Re: Gemmer PRD, 1125 & 1507 172nd Street NE (PA22-007)

SUBJECT: PA 22-007 – Gemmer PRD

RE: Gemmer PRD, File# PA22-007
Proposed 182-lot PRD Subdivision, utilizing residential density incentives, and associated improvements. Proposed Boundary Line Adjustment to align split zoned parcel with proposed development.

To: Amy Hess, Senior Planner
From: Don McGhee, Assistant Fire Marshal
Date: August 9, 2022
Subject: PA22-007 Gemmer PRD 1125 & 1507 172nd St NE

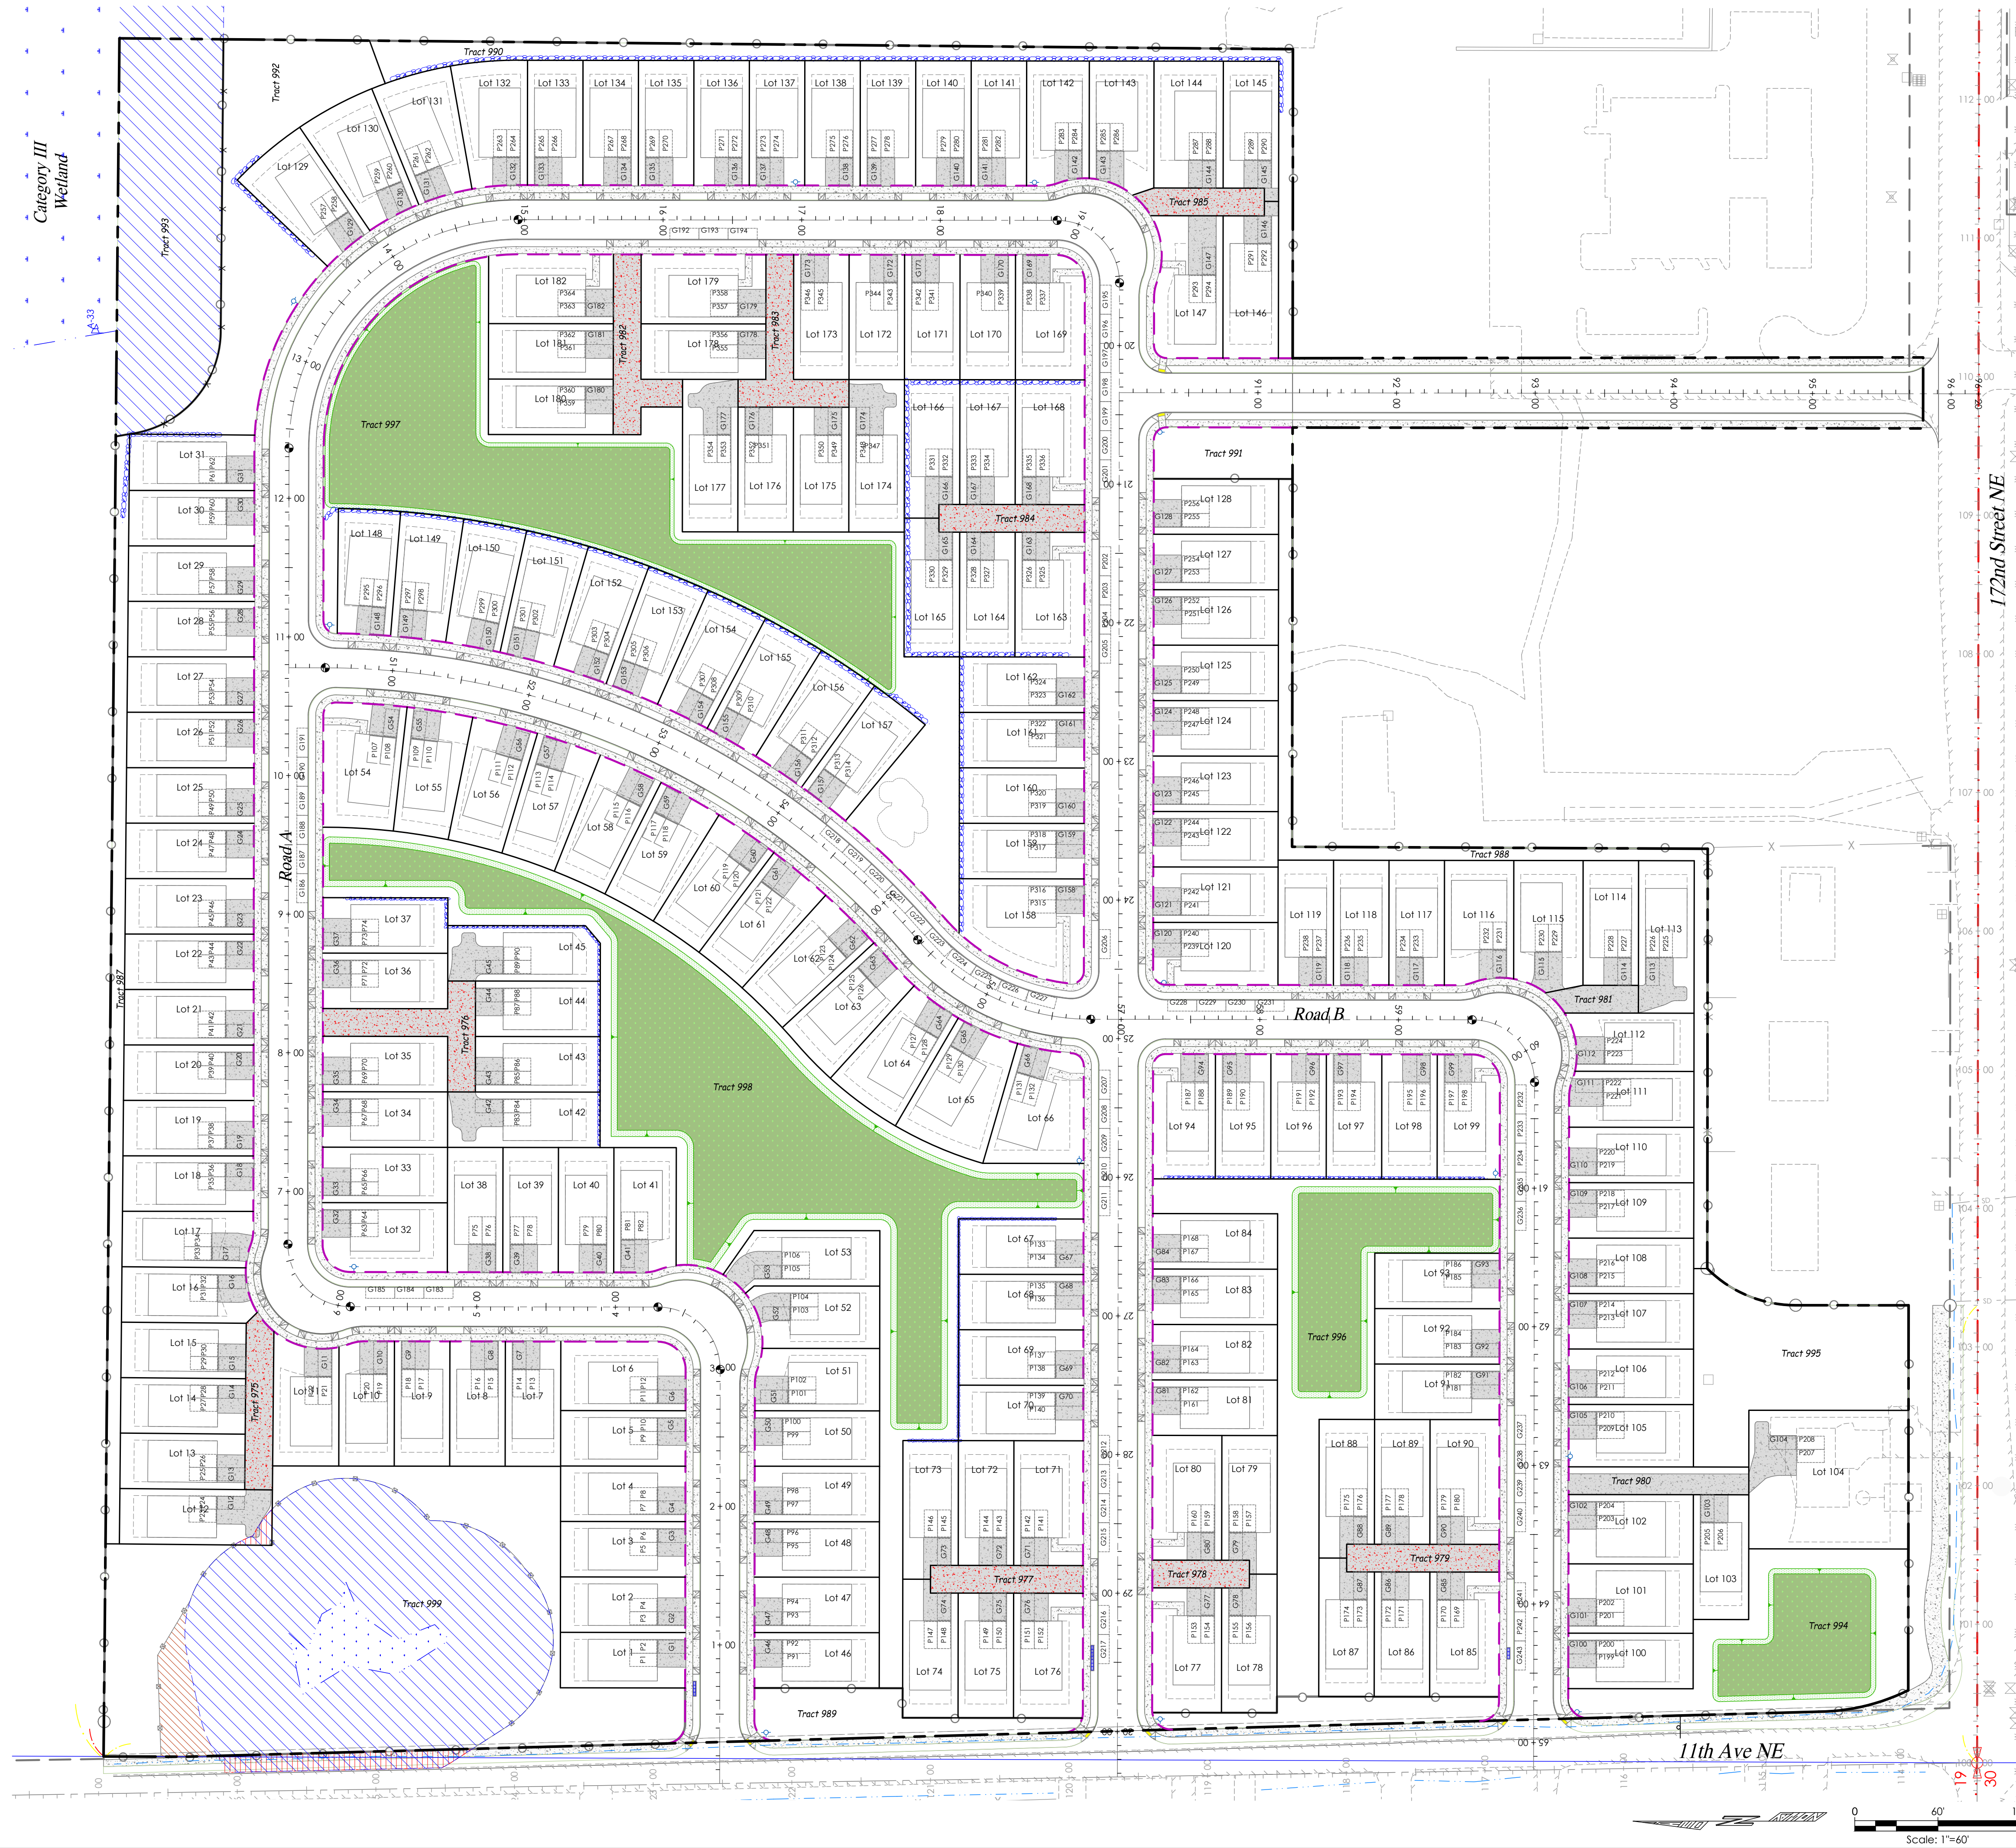
- b. *Auto court tract 985 may need to have the apron area adjusted so as to promote better sight angle.*
 - c. The southern access onto 11th Ave will need to meet the spacing requirement from the future roundabout. *The travel lane should have 230 feet of separation.*

- d. Please provide a conceptual drawing of the roundabout located at the intersection of 11th Ave NE and 172nd St NE. *I did not see the conceptual drawing in the resubmittal.*
